## Haley Rich - Orica Kooragang Island AN Facility (08\_0129 Mod 1) - Response To Incitec Pivot Submission

**From:** <richard.sheehan@orica.com>  
**To:** Haley Rich <Haley.Rich@planning.nsw.gov.au>  
**Date:** 9/2/2011 5:28 PM  
**Subject:** Orica Kooragang Island AN Facility (08\_0129 Mod 1) - Response To Incitec Pivot Submission  
**CC:** Felicity Greenway <Felicity.Greenway@planning.nsw.gov.au>, Lilia Donkova <Lilia.Donkova@planning.nsw.gov.au>, <carey.gent@orica.com>

Figure 3-16: Site IFR - MOD 1 (v6.7)

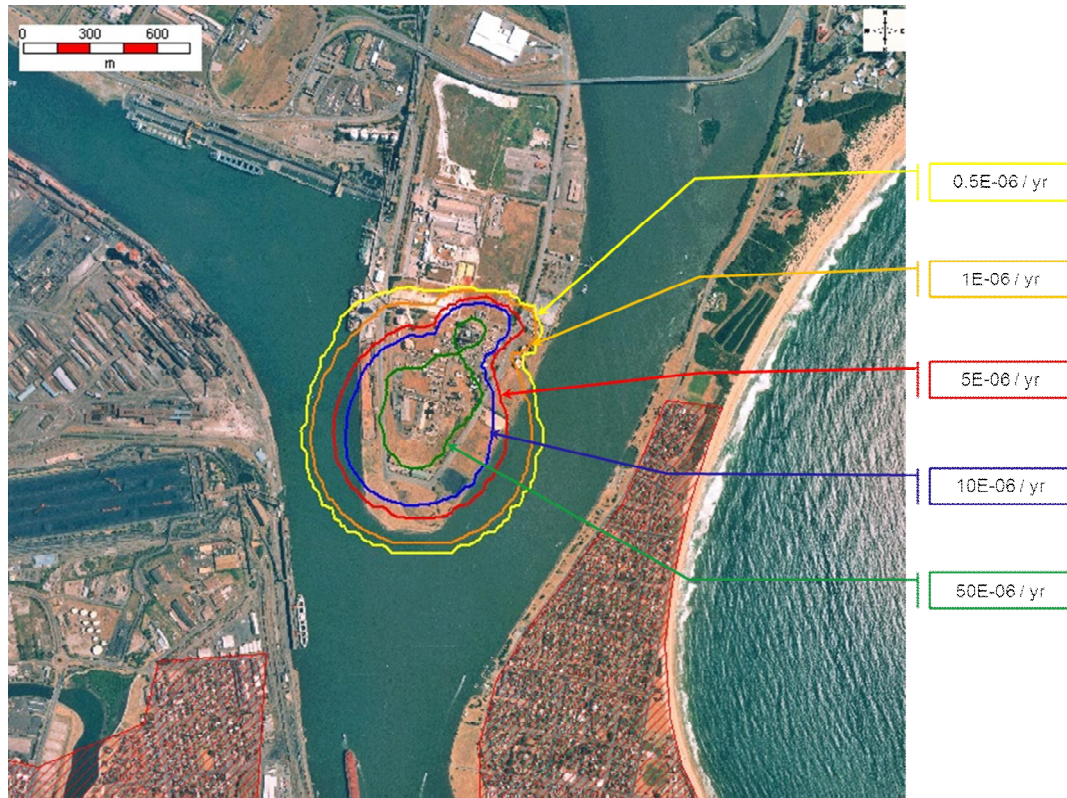
*"I have a concern that the Orica modification has increased the IFR risk from 56E-06 to 60E-06 pa at the northern boundary (see Table 1 in PHA MOD 1 Report). The modification should not increase the level of risk with the Incitec Pivot boundary."*

In reviewing this submission from Incitec Pivot, Orica has reviewed the modelling results at the northern boundary in more detail and has identified that the positioning of the northern boundary at which the results were published was conservative. Correction of the northern site boundary position to comply with the actual property boundary line has resulted in a reduction of the calculated risk at the northern boundary from 56-E06 to 48-E06 for the original PHA and 60-E06 to 53-E06 for the modification. For the modification, the 50E-6 contour extends only slightly (approximately 10m) over the Orica northern boundary onto largely vacant land.

Orica submits that the minor increase in risk from 48E-6 to 53E-6 is marginal. Orica also highlights the Guidance Notes in HIPAP 4 2011 (Section 3, note 5) pertaining to adjacent industrial sites, the nature of activities and the presence of people. If you have any questions in relation to this response please do not hesitate to contact me as per the details below.
